KITTITAS COUNTY

MEMORANDUM

TO: All Staff
FROM: Public Works Plan Review Team
DATE: November 7, 2024
SUBJECT: AU-24-00006 Firl

SITE PLAN

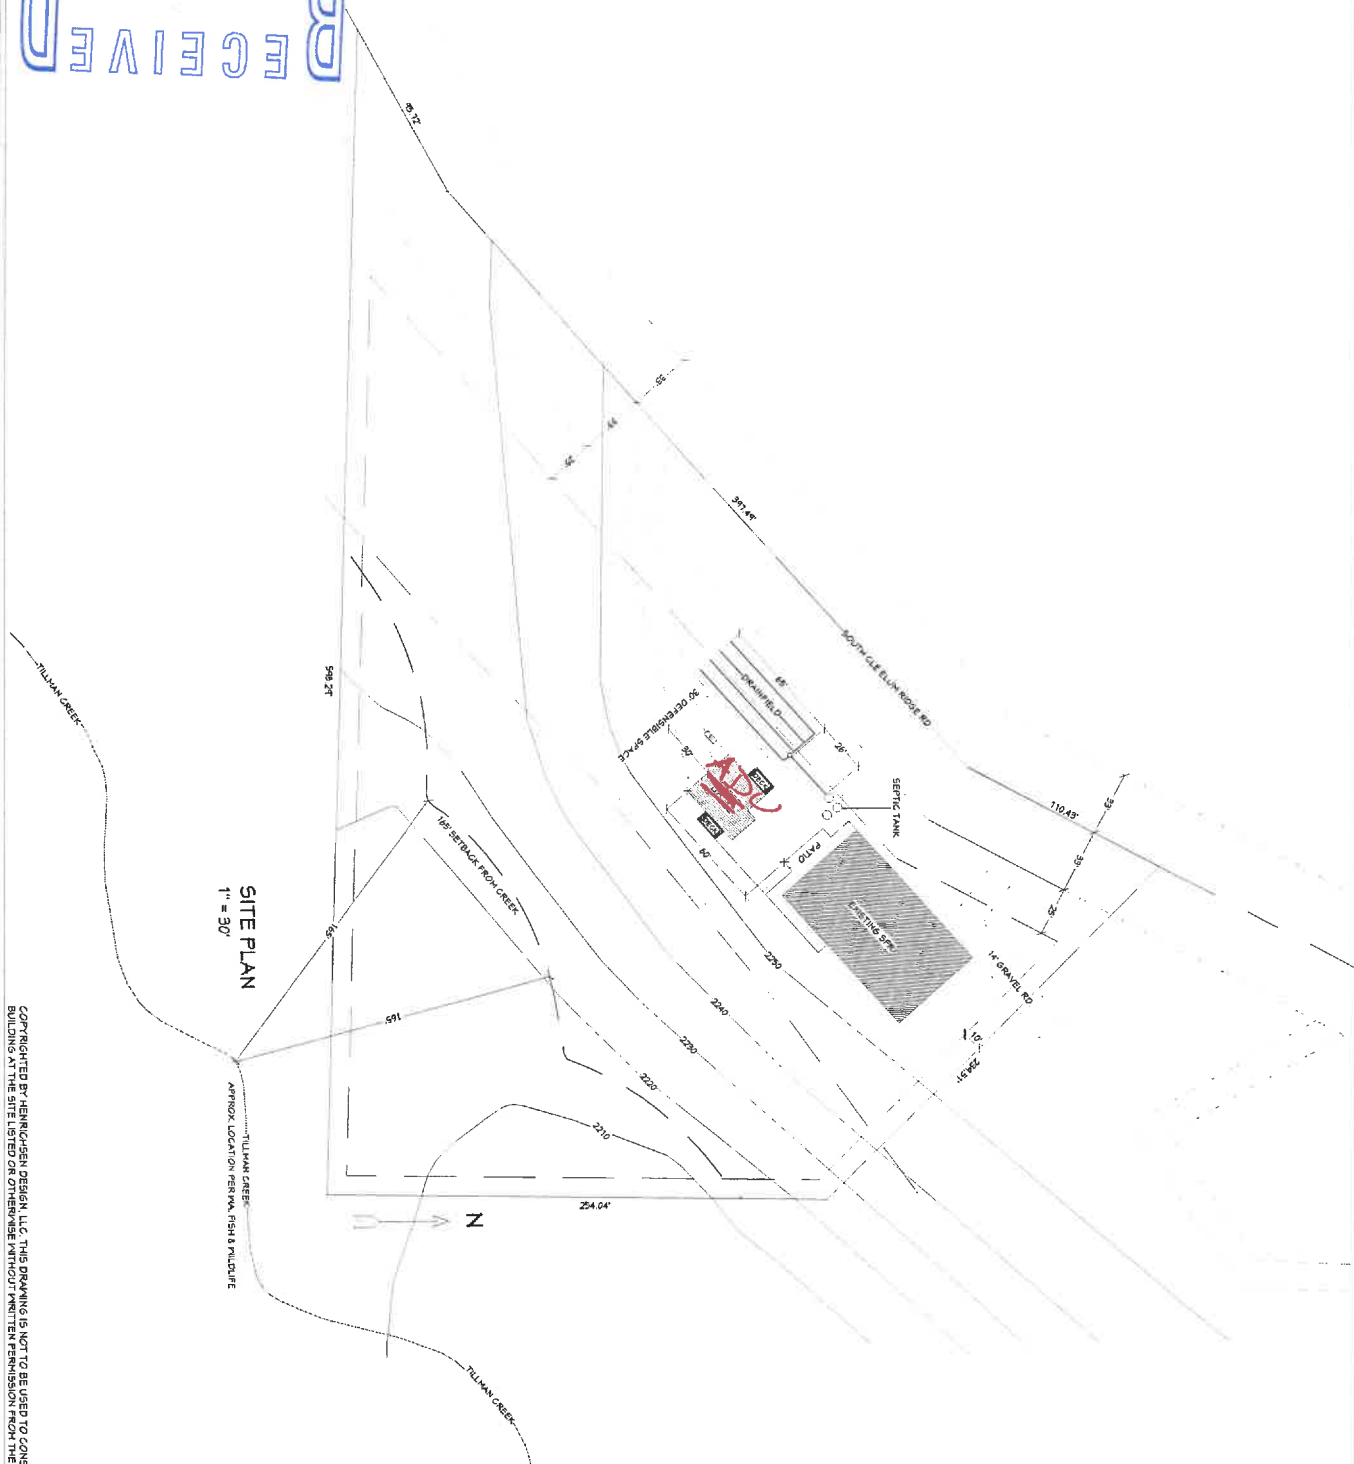
ACCESS	<ol style="list-style-type: none">1. Parcel 956834 has an approved access permit (AC-23-00008) on file with Public Works. As proposed, the existing access will be used to serve this ADU.2. Maintenance of driveway approaches shall be the responsibility of the owner whose property they serve. The County will not maintain accesses.3. Any further subdivision or lots to be served by proposed access may result in further access requirements. See Kittitas County Road Standards Title 12.4. In addition to the above-mentioned conditions, all applicable Kittitas County Road Standards apply to this proposal. Access is not guaranteed to any existing or created parcel on this application. (JS)
ENGINEERING	Except as exempted in KCC 14.05.060, no grading or filling upon a site involving more than one hundred (100) cubic yards shall be performed without a grading permit from the County Engineer or Public Works designee (KCC 14.05.050). An application for grading in excess of five hundred (500) cubic yards shall be accompanied by an engineered grading plan (KCC 14.05.080). (CP)
